Consultation Response: Kirklees Council Conservation & Design

Date	29/07/2016
Officer	Tom Stephenson
Purpose	Review of ecological reports submitted in support of application 2016/92041. Reviewed reports include: 1. Bat Survey
Location	Poplar Farm, Bristfield Road, Bristfield, Dewsbury, WF12 0PA

Drawing Title
Site Plan

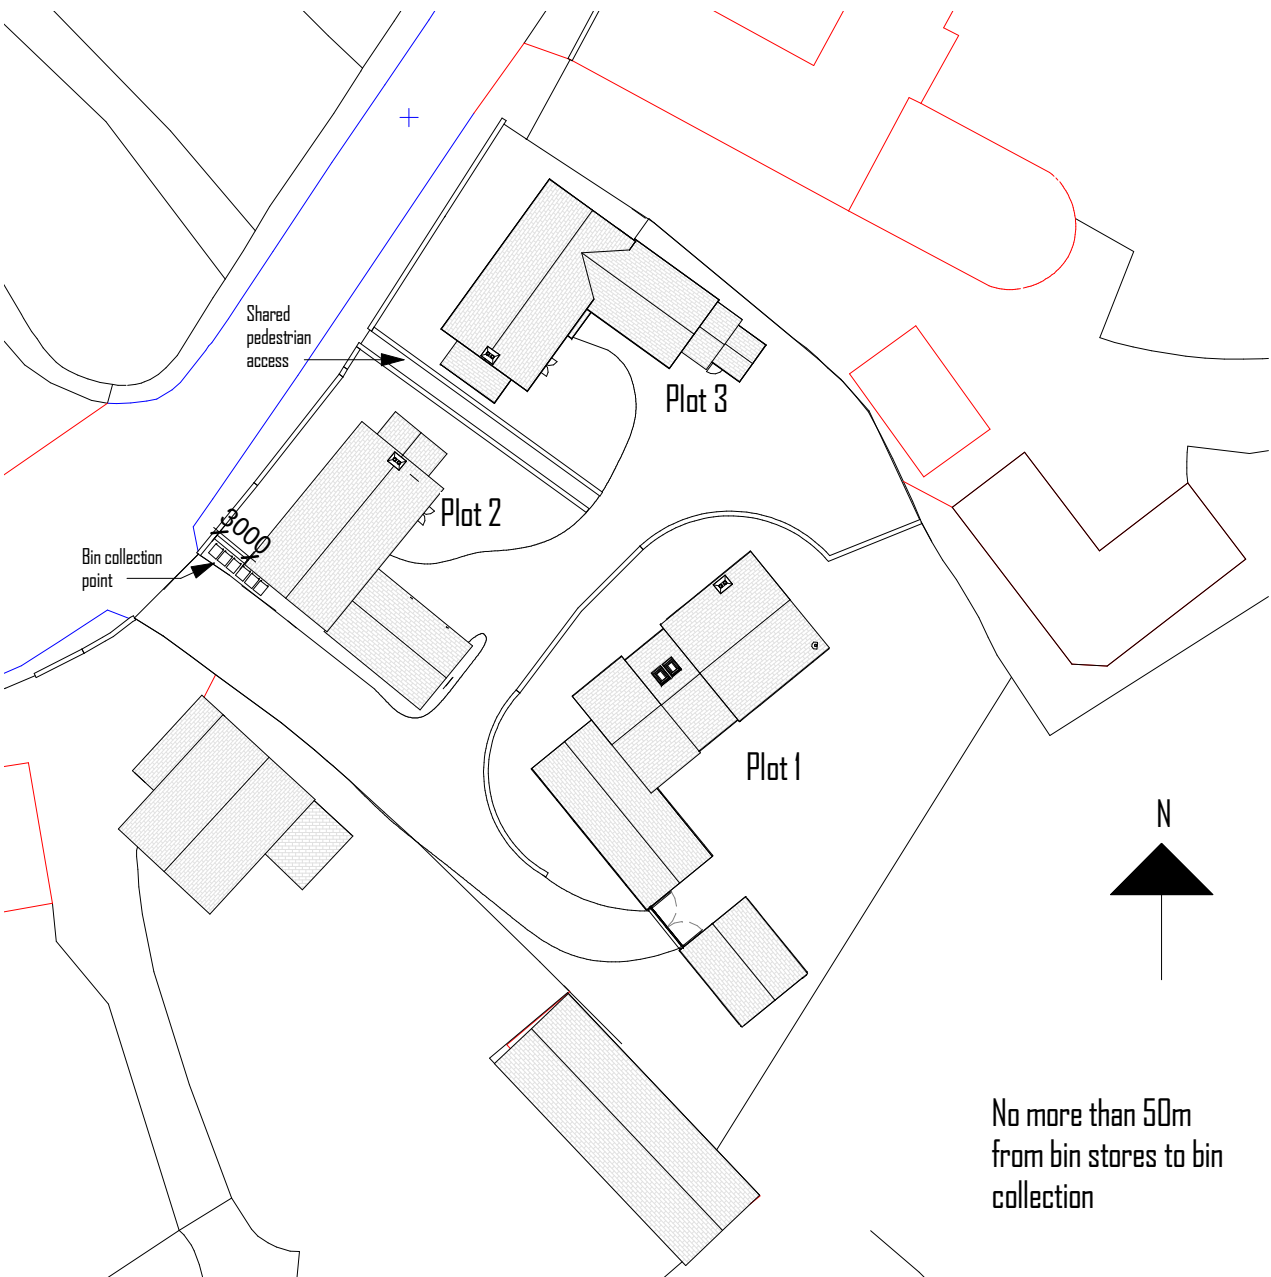
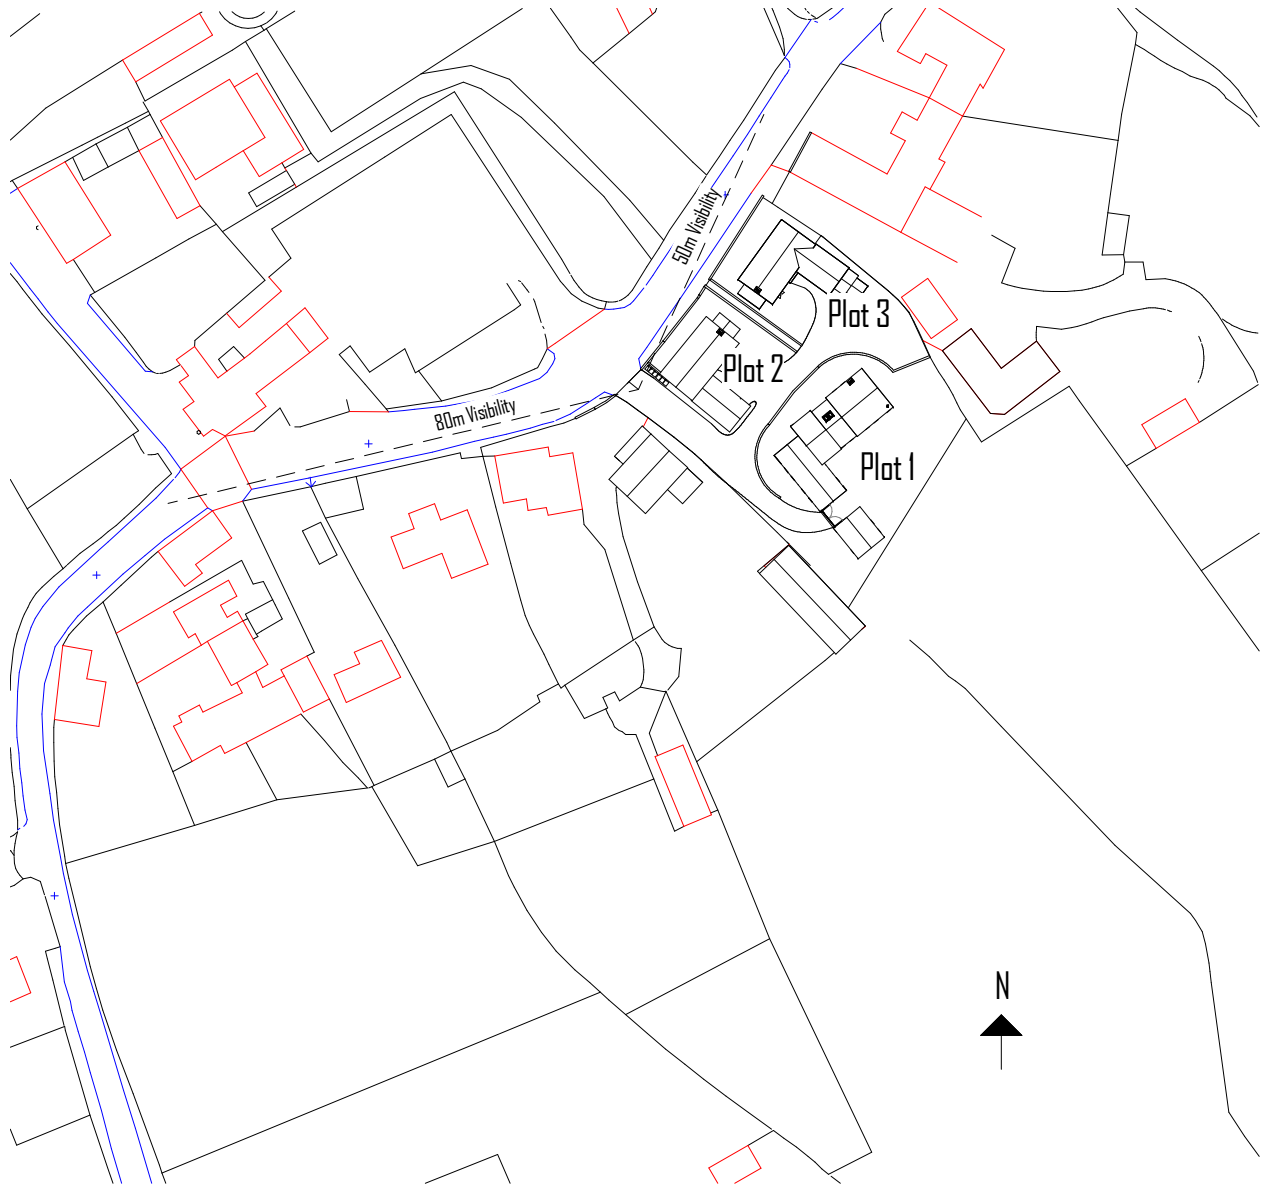
Enhancement in the form of inclusion of bat boxes in the new buildings has been recommended, which I support. Although, due to the level of foraging bat activity recorded, and the connectivity of the site with surrounding land and likely high value bat commuting routes (the site is within the Kirklees Bat Alert GIS layer covering Bristfield Beck), detail of how this connectivity will be protected is required.

In particular, mitigation should be aimed at providing replacement bird nesting habitat and maintaining connectivity for foraging bats throughout the site. Connectivity can be maintained through a combination of landscape planting, such as well positioned hedgerows, and dark corridors where no artificial lighting will fall. These measures could be presented in a Landscape and Ecological Management Plan (BSI, 2013).
